**RE: LANG WALKER AO MEDICAL RESEARCH BUILDING – MACARTHUR STATE SIGNIFICANT DEVELOPMENT APPLICATION SSD-17491477**

**RESPONSE TO DEPARTMENT OF PLANNING AND ENVIRONMENT REQUEST FOR ADDITIONAL INFORMATION**

**Table 1:** Project team response to DPE request for information

Figure 25 – Flood Impact Assessment Map (1% AEP Flood event)

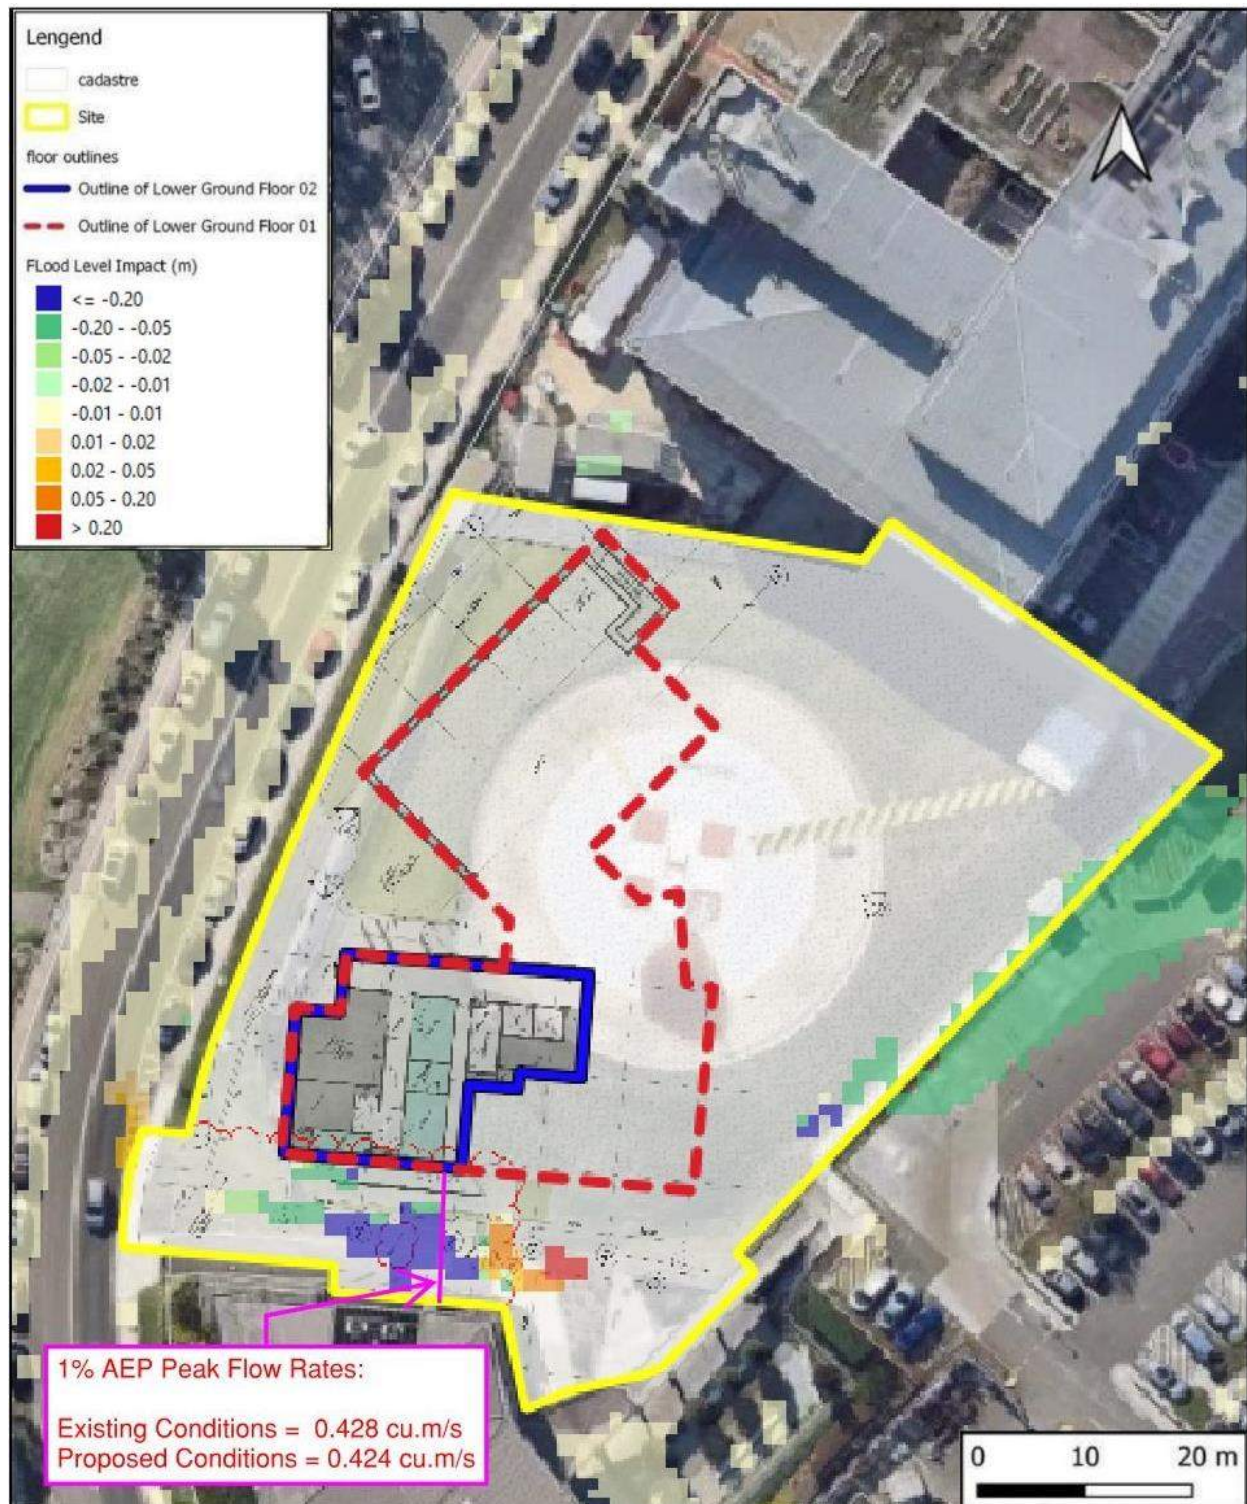
| Issue Raised                                                                                                                                                                                                                                                                                                                                                             | Project Team Response                                                                                                                                                                                                                                                                                                                                                                                                                                                                                                                             | ✓ |
|--------------------------------------------------------------------------------------------------------------------------------------------------------------------------------------------------------------------------------------------------------------------------------------------------------------------------------------------------------------------------|---------------------------------------------------------------------------------------------------------------------------------------------------------------------------------------------------------------------------------------------------------------------------------------------------------------------------------------------------------------------------------------------------------------------------------------------------------------------------------------------------------------------------------------------------|---|
| Figure 25 of the revised Flood Assessment Report (25 March 2022) should be amended to demonstrate a band of -10mm to +10mm level difference, as noted in the report.                                                                                                                                                                                                     | An amended Flood Assessment Report correcting Figure 25 has been prepared. Please refer to <b>Appendix B</b> .                                                                                                                                                                                                                                                                                                                                                                                                                                    | ✓ |
